PROPOSALS FOR THE DEVELOPMENT OF WEST BURTON C (EN010088):
THE FORMAL RESPONSE OF BOLE VILLAGERS FOR DEADLINE 2

James Naish, District Councillor for Sturton Ward, on behalf of Bole villagers
18th December 2019

Figure 2. HGV Designated Route Plan (Proposed Development Construction)

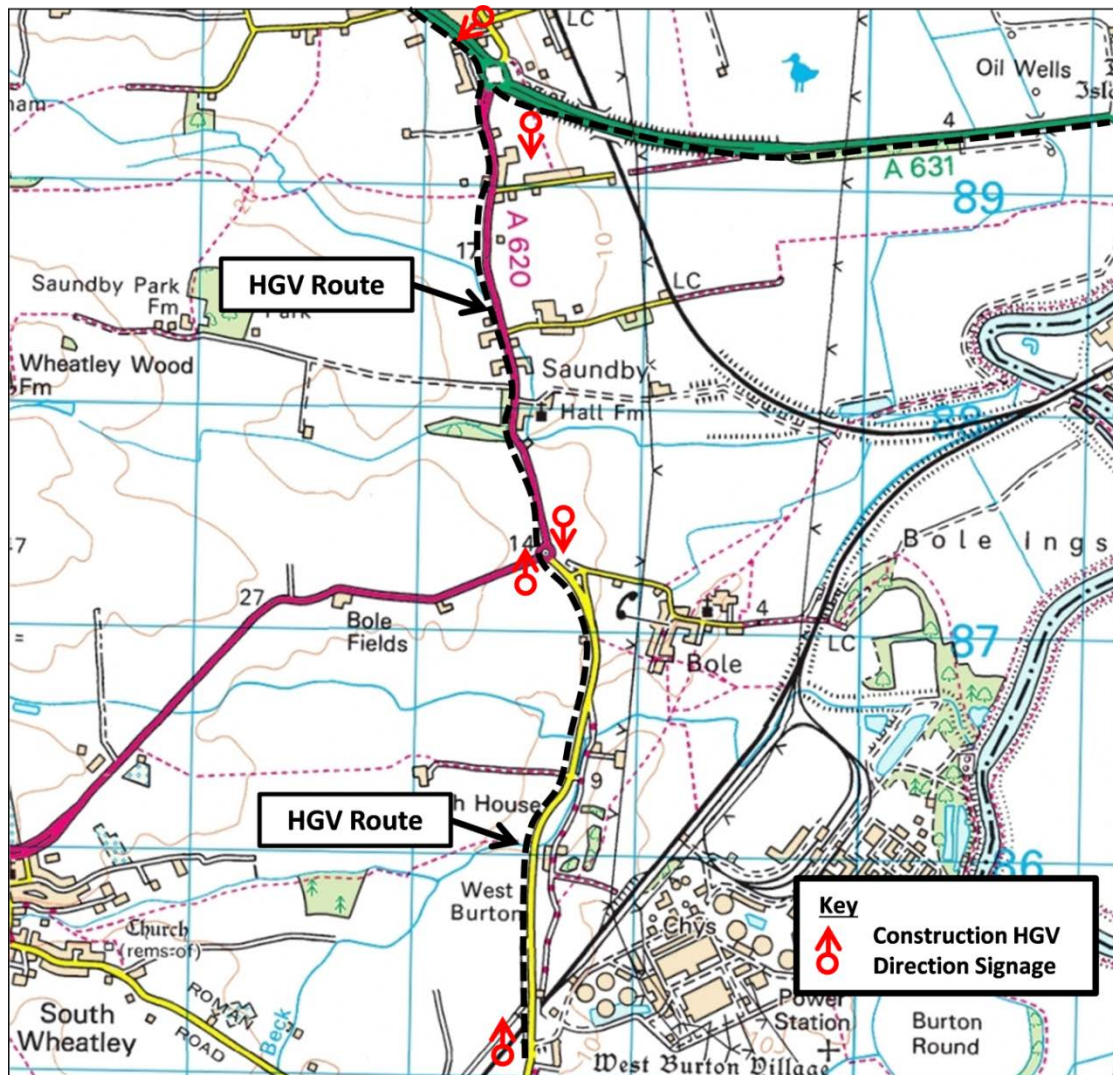
Original request	EDF Energy's proposal	Bole villagers' response
<p>1. We would like EDF Energy to commit to working with relevant local authorities and regulatory bodies to do everything within its power to limit, and ideally stop, Bole lay-by being used by construction-related traffic. This should be a top priority from the moment planning is approved, and we would like EDF Energy to commit to throwing its legal expertise behind this matter if needed. We would like this lay-by to be closed permanently if possible.</p>	<p>If the project goes ahead and to address points 1 and 6 here, EDF agree to contribute of up to a total of █████ towards reasonable costs for investments to reduce traffic impacts from the outset of the project, such as a camera on the layby and/or an HGV sign. This is on the understanding that this infrastructure would be installed, operated and maintained by others.</p>	<p>This proposal was welcomed by Bole villagers who would look to other authorities (e.g. Bassetlaw District Council and Nottinghamshire County Council) to match funding where appropriate to meet the desired objectives.</p> <p>It was noted that further funding might be required if there were genuine, unexpected grievances resulting from the proposed build. Such issues would be raised via the Community Liaison Officer in due course. To be clear, all parties hope that this won't be necessary as a result of the proposed upfront investment.</p>

<p>2. To facilitate the above, we would like EDF Energy to commit to providing sufficient parking for all contractor vehicles on site, 24 hours per day. We would like this commitment – and a suitable site to be identified, with appropriate facilities – as part of planning application EN010088. We would also like correct geographical</p>	<p>Please see Planning Inspectorates website, Applicant's Comments on Relevant Representations/Document Ref. 8.2.</p>	<p>The proposal for onsite parking was welcomed by Bole villagers.</p> <p>However, it would like further assurances in writing (1) that the parking will be accessible to drivers 24 hours a day; (2) that drivers will be purposefully directed to this site; and (3) that appropriate facilities will be</p>

Original request	EDF Energy's proposal	Bole villagers' response
<p>coordinates to be shared with all contractor vehicles, to prevent HGVs getting stuck in Bole village.</p>		<p>provided for drivers (e.g. toilets).</p> <p>On the assumption that all three of these points are met, this is a significant improvement vs. driver provision during the construction of West Burton B, and is warmly welcomed.</p>
<p>3. We would also like EDF Energy to commit to investing in the effective visual screening of all West Burton developments for the village of Bole, including West Burton A and West Burton B. Similar commitments were made when West Burton B was built but these were not – unfortunately – effectively implemented. It would be unacceptable for this to happen again. Bole villagers would like to be consulted about such schemes as early as possible, and for them to be executed before on-site construction at West Burton C begins.</p>	<p>The community fund of █████ per year for each year of construction is intended to allow the community to invest in projects and could potentially be used to provide visual screening.</p>	<p>Bole residents welcomed the idea of a community fund.</p> <p>However, there were concerns that █████ per year would only cover the cost of between 10 and 25 mature trees per annum, which would have a limited impact on the desired screening. Residents also noted that they aren't experts in such matters, and felt that EDF Energy should be assisting more directly in achieving the desired objective. Access to EDF land may be required to facilitate effective screening.</p> <p>Further thinking on this item is recommended.</p>
